Details: **Change of use of former domestic garage to beauty salon at Byshell Main Road  
Crimplesham Norfolk PE33 9DX**

I have received a planning application as detailed above but cannot process it until I receive some more information:

FLOOR PLAN OF BUILDING TO BE USED AS BEAUTY SALON

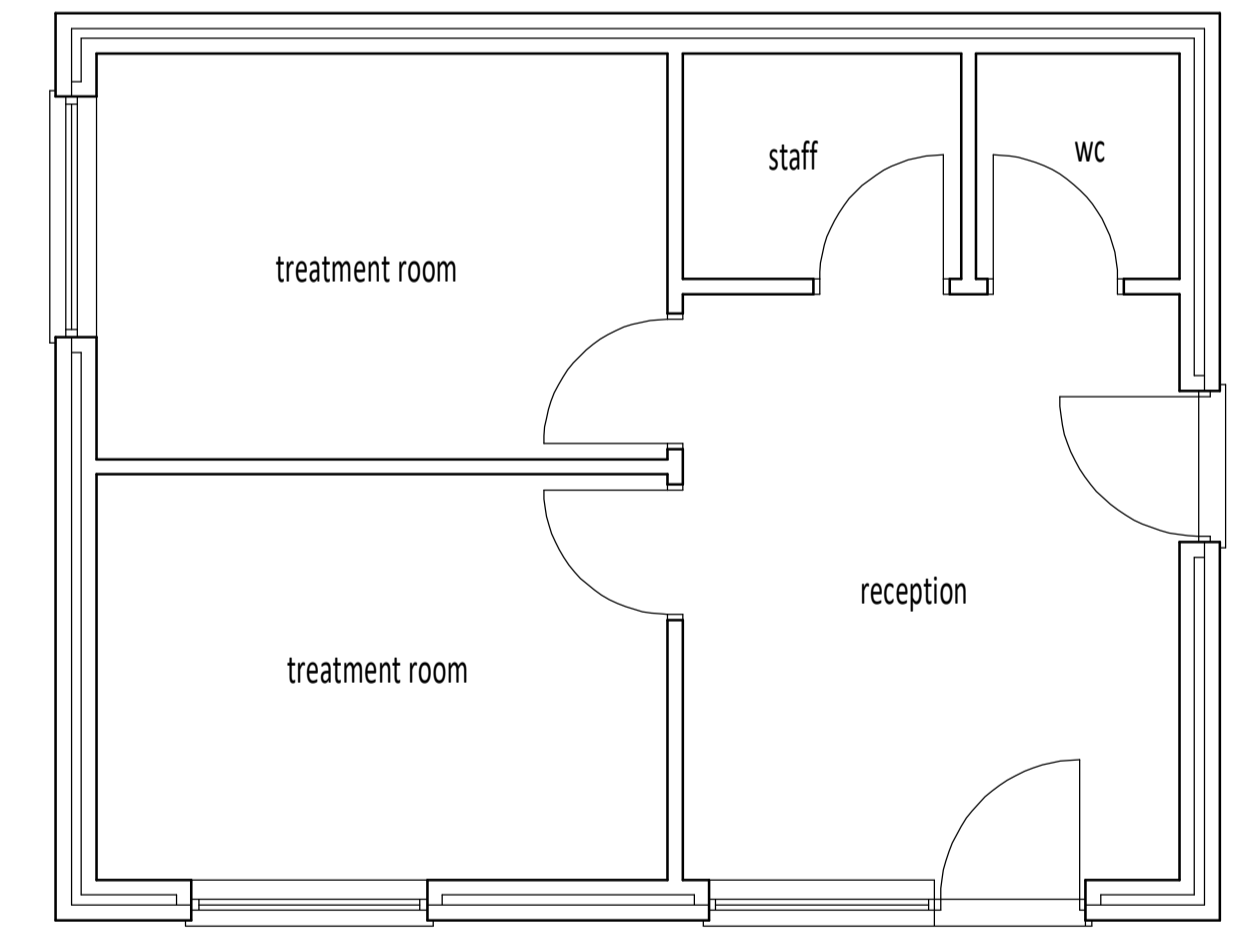
1. Are there any changes to the building such as extra windows/doors? If there isn't any changes please can you label the floor plan existing and proposed. If there are changes please submit an existing floor plan and existing and proposed elevations to a scale of 1:50 or 1:100.
